City of Portland, Maine - Building or Use Permit Application
 389 Congress Street, 04101 Tel: (207) 874-8703, Fax: (207) 874-8716

Permit No: 04-1679	Issue Date:	CBL: 026 C005001
------------------------------	--------------------	----------------------------

Location of Construction: 54 Chestnut St	Owner Name: Mardigan Edward L	Owner Address: 11 Bayview Ter	Phone: 774-1054
Business Name:	Contractor Name: Great Falls Builders, Inc.	Contractor Address: 27 Wards Hill Rd Gorham	Phone: 2078922744
Lessee/Buyer's Name	Phone:	Permit Type: Alterations - Multi Family	Zone:

Past Use: Three family dwelling units used as family shelter for the City	Proposed Use: Three family dwelling units used as family shelter for the city - w/new enclosed stairwell and remodeling - remove fire escape	Permit Fee: \$354.00	Cost of Work: \$36,871.00	CEO District: 1
Proposed Project Description: Remove fire escpae and construct new stairwell at family shelter		FIRE DEPT: <input type="checkbox"/> Approved <input type="checkbox"/> Denied	INSPECTION: Use Group: Type	
		Signature:	Signature:	
PEDESTRIAN ACTIVITIES DISTRICT (P.A.D.)				
Action: <input type="checkbox"/> Approved <input type="checkbox"/> Approved w/

**SECTION**  
 AT  
 SCALE 1/4"=1'-0"

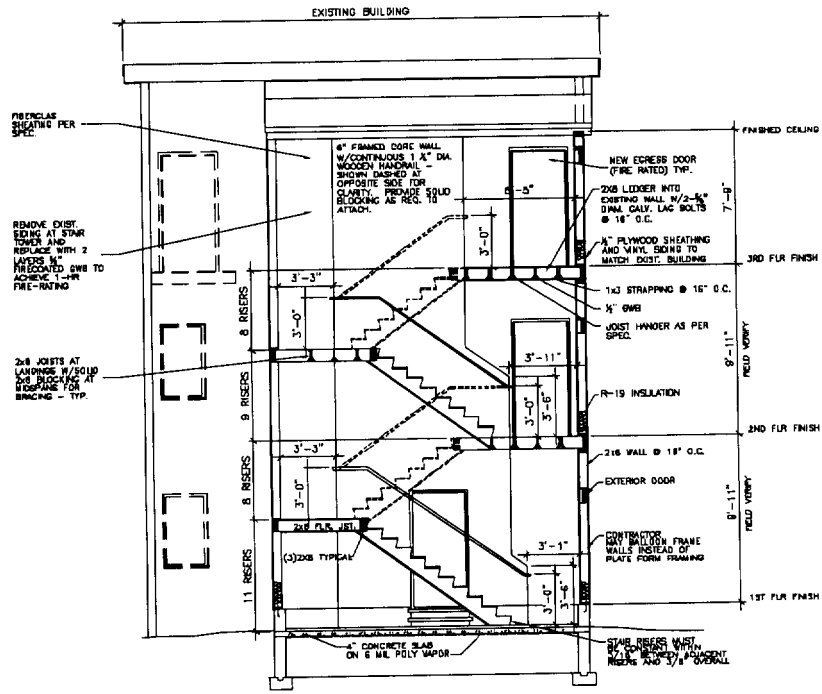
1) No Nosings.....see evolution of plans..guard must be 42"			
Dept: Fire	Status: Approved with Conditions	Reviewer: Lt. MacDougal	Approval Date: 11/17/2004
Note:			Ok to Issue: <input checked="" type="checkbox"/>

1) handrails shall be a minimum of 1 1/2" to a maximum of 2" in diameter			
2) stairs shall be a maximum of 7" riser and a minimum of 11" tread			
3) the fire alarm system shall be extended to the new stairwell

Comments:
11/24/2004-mjn: Stairs must not have nosings, need guard and handrail info. Cliff Marchant was notified
12/09/2004-gg: received granted site plan exemption. /gg
